Your Ref: SSD-10352-Mod-1
Our Ref: SSD-1/2025

**State Significant Development Application (SSD-10352-Mod-1)
Moriah College, 101 York Road and 1-3 Queens Park Road, QUEENS PARK NSW 2022
(Waverley Council Ref.: SSD-1/2025)**

Figure 10 Proposed eastern elevation

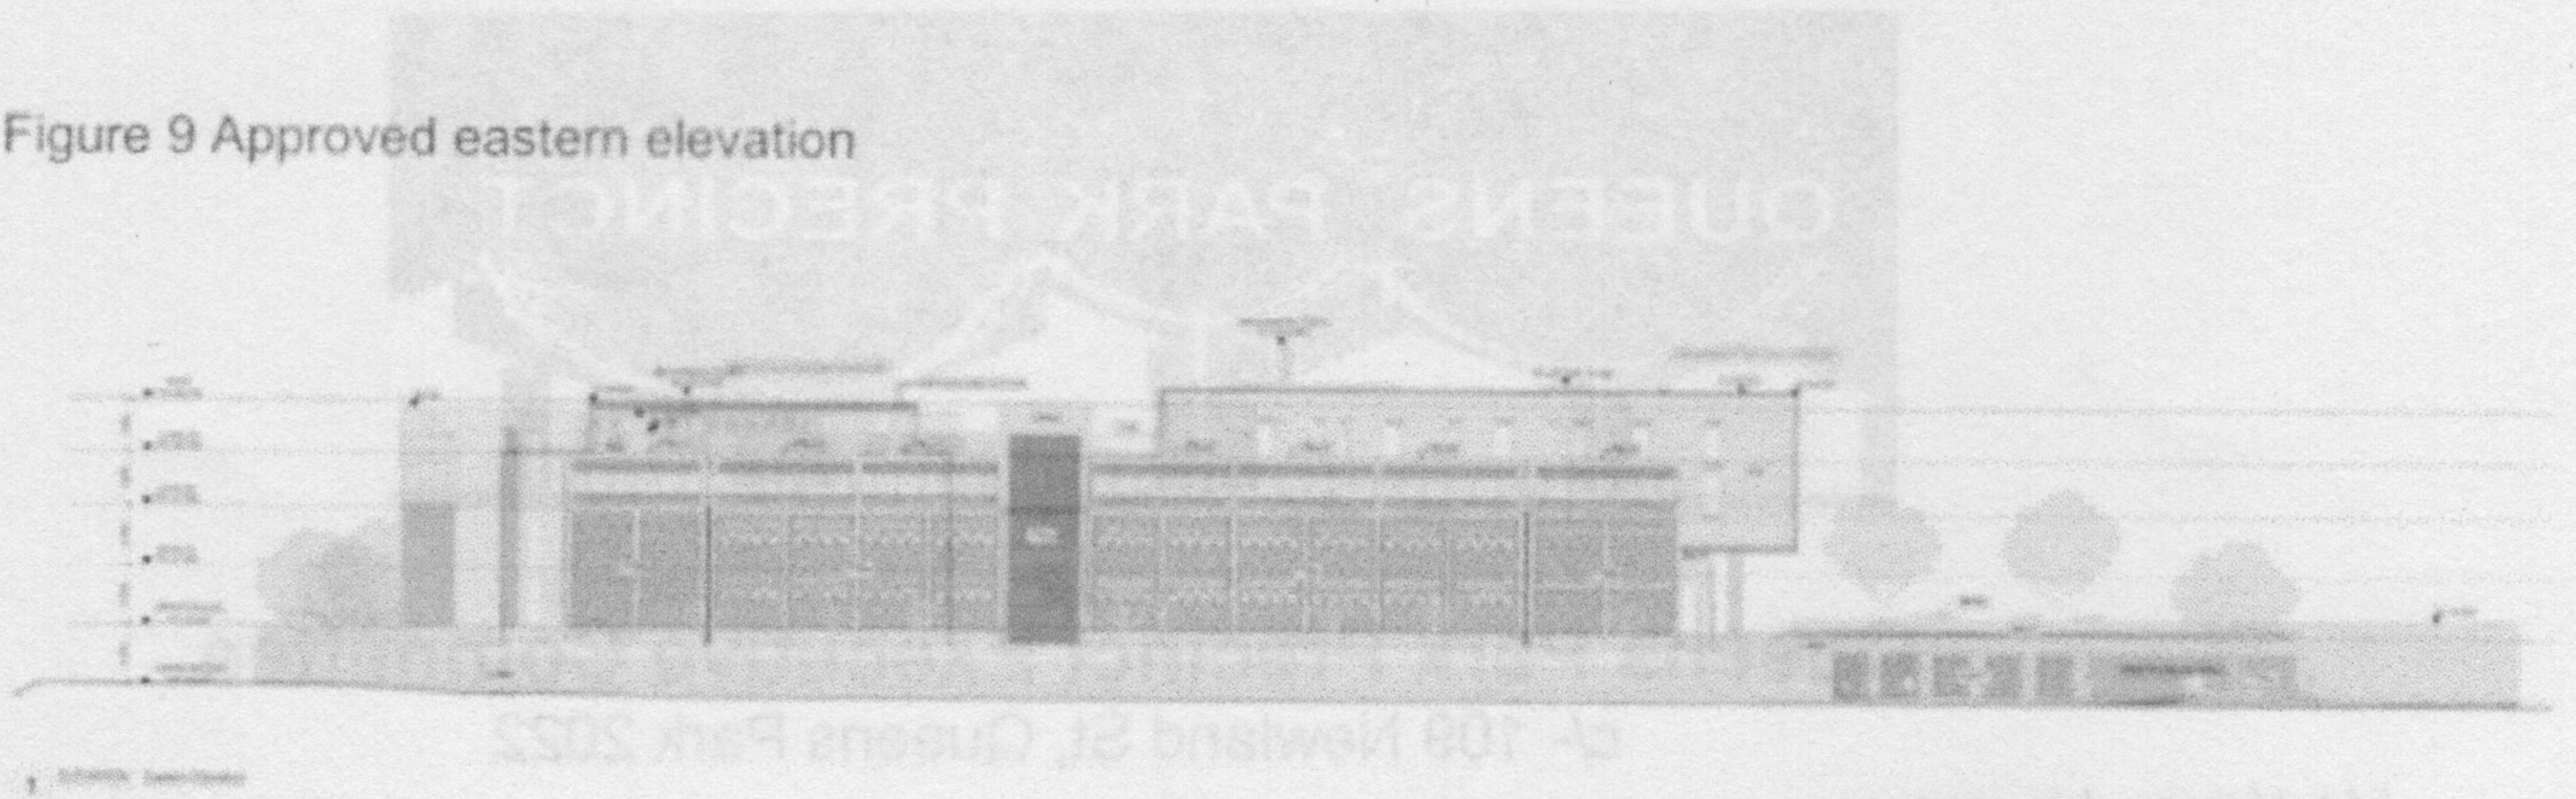
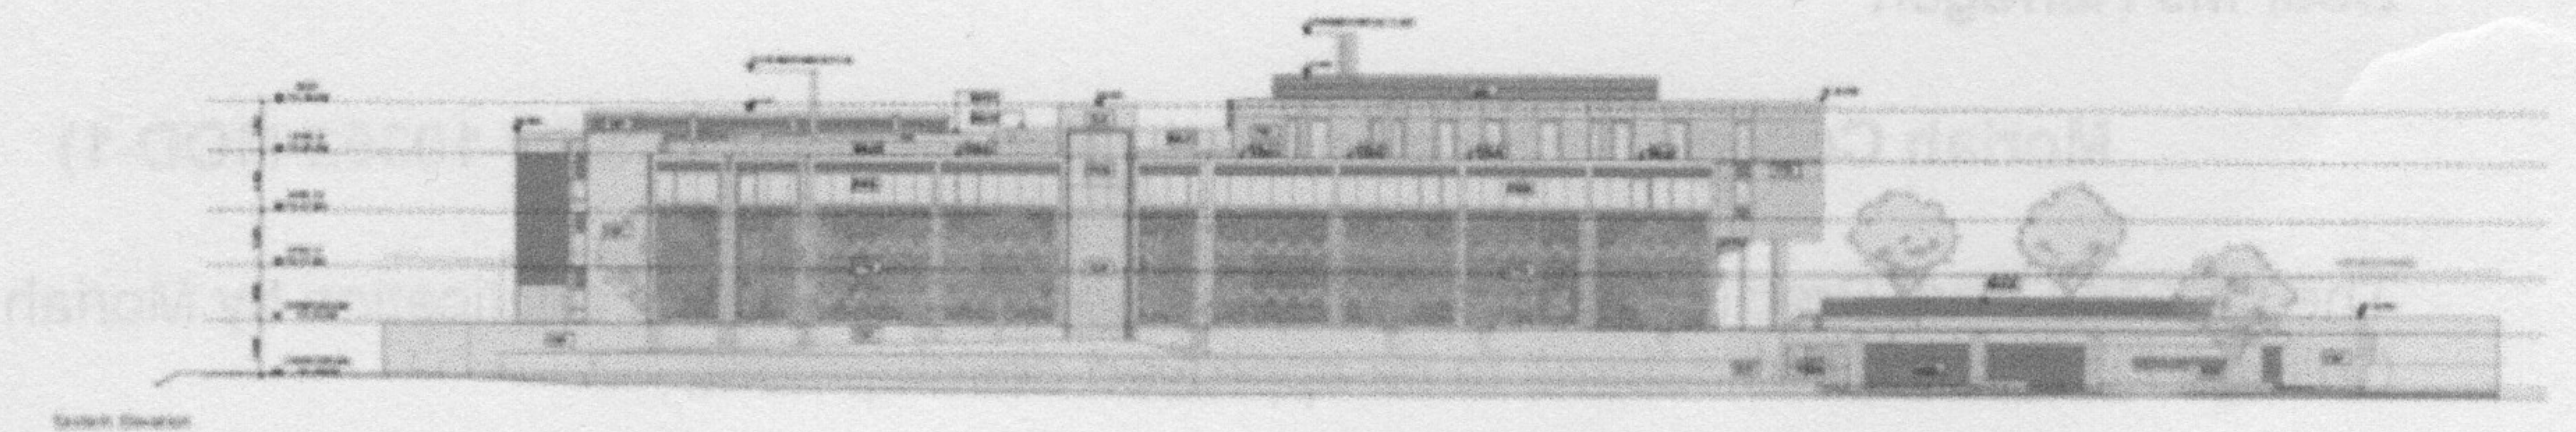
Council acknowledges that the application of the height of buildings development standard under Waverley Local Environmental Plan 2012 to the SSD is suspended by State Environmental Planning Policy (Infrastructure) 2021. The increase of the overall building height of the approved development, as proposed to be modified, is generally satisfactory by virtue of the building not significantly extending above the predominant tree canopy line when the development is viewed from inside and the eastern portions of Queens Park. However, careful consideration should be given to the design quality of the additional open air plant enclosure and flues in terms of the visual impact of these on the architecture of the building and how these are perceived upon the surrounding parklands. Exploration of material and colour palettes could be one option to ensure these elements are as inconspicuous as possible from the surrounding public domain.
